About the application

Application number: 2025/93355	
What is the application for?:	Erection of 75 residential dwellings with associated landscaping, open space, hi
Address of the site or building:	Land off, Woodward Court, Mirfield, WF14 0PY
Postcode:	LS15 8ZB

Type of comment: An objection	
Do you wish your comments to be published on the website anonymously?	Yes

## **Appendix H Proposed Woodward Court Site Access & Wellhouse Lane Improvements (Optima Drawing.25033/GA/02)**

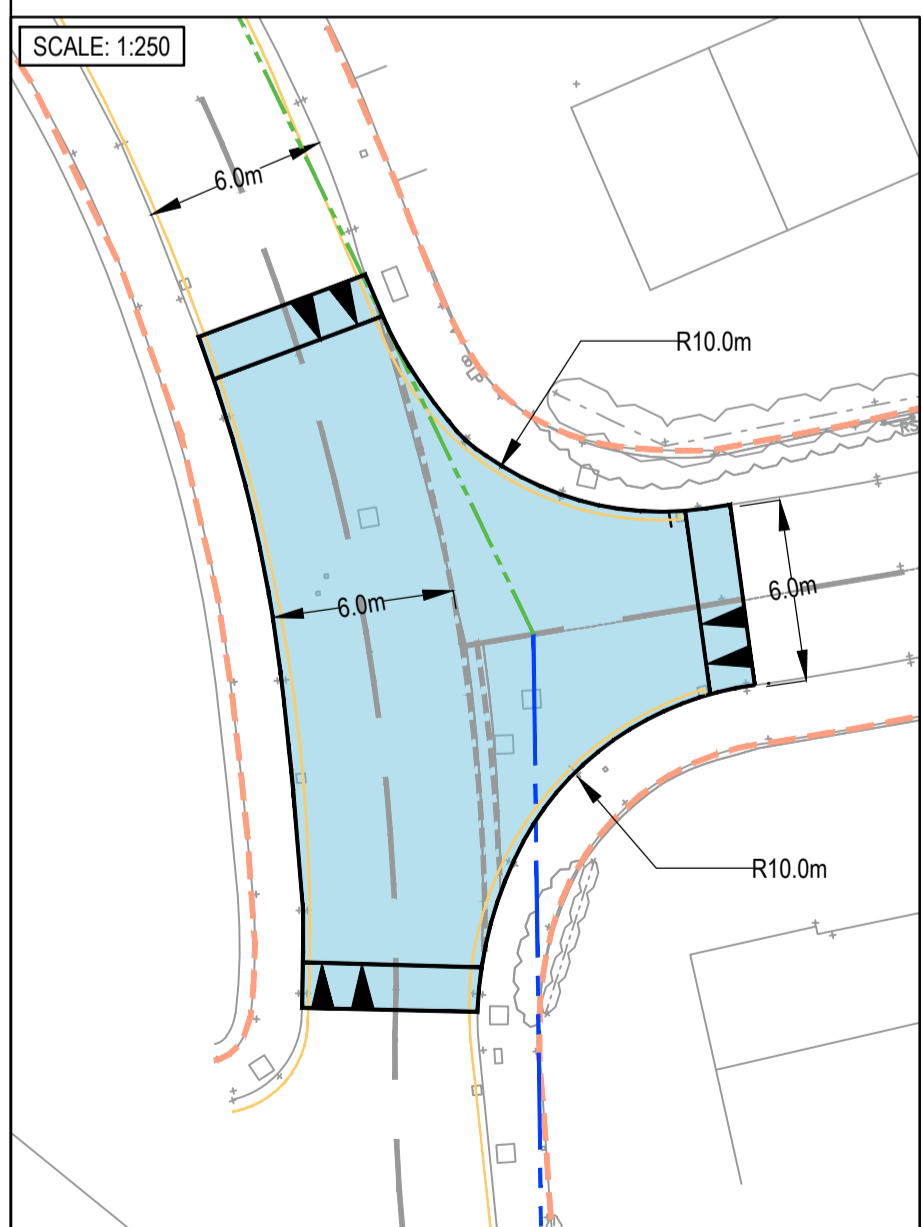
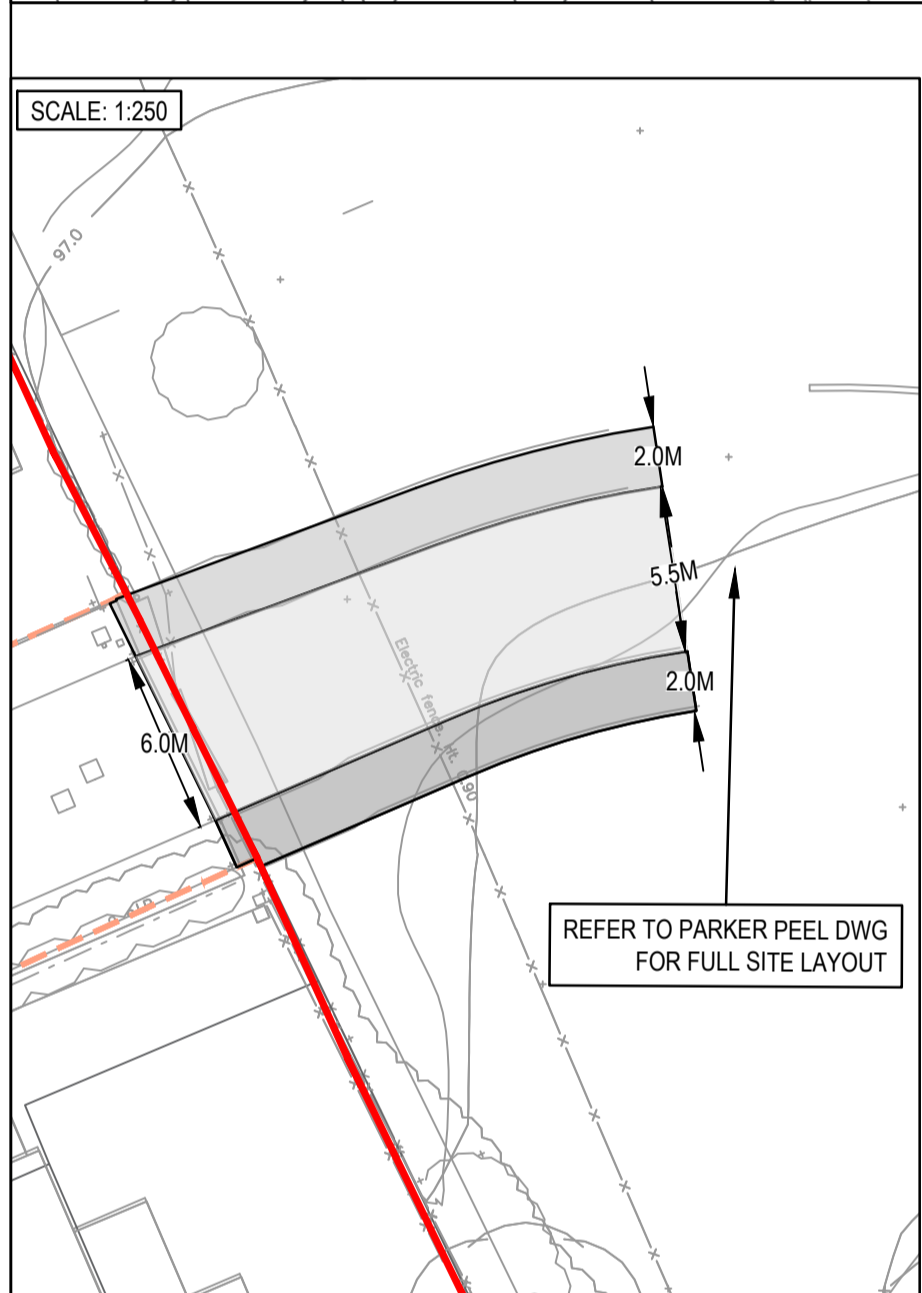
The proposed layout of the site indicates 2 points of access – apparently with the Hepworth Lane junction being an EXIT ONLY from the estate. Unless the Council proposes to adopt the estate roads (which would be a departure from current policy and give Bellway Homes a material advantage over other developers), it has little or no ability to enforce traffic restrictions on private roads and therefore I have to question how it intends to enforce a policy of ONLY allowing traffic to exit the estate onto Hepworth Lane. It cannot make Hepworth Lane a one way street as this will only force traffic back onto Wellhouse Lane at its westerly junction. This lack of enforceability will further contribute to unsafe conditions, and any increase in traffic will worsen the situation without any mechanism for effective management.
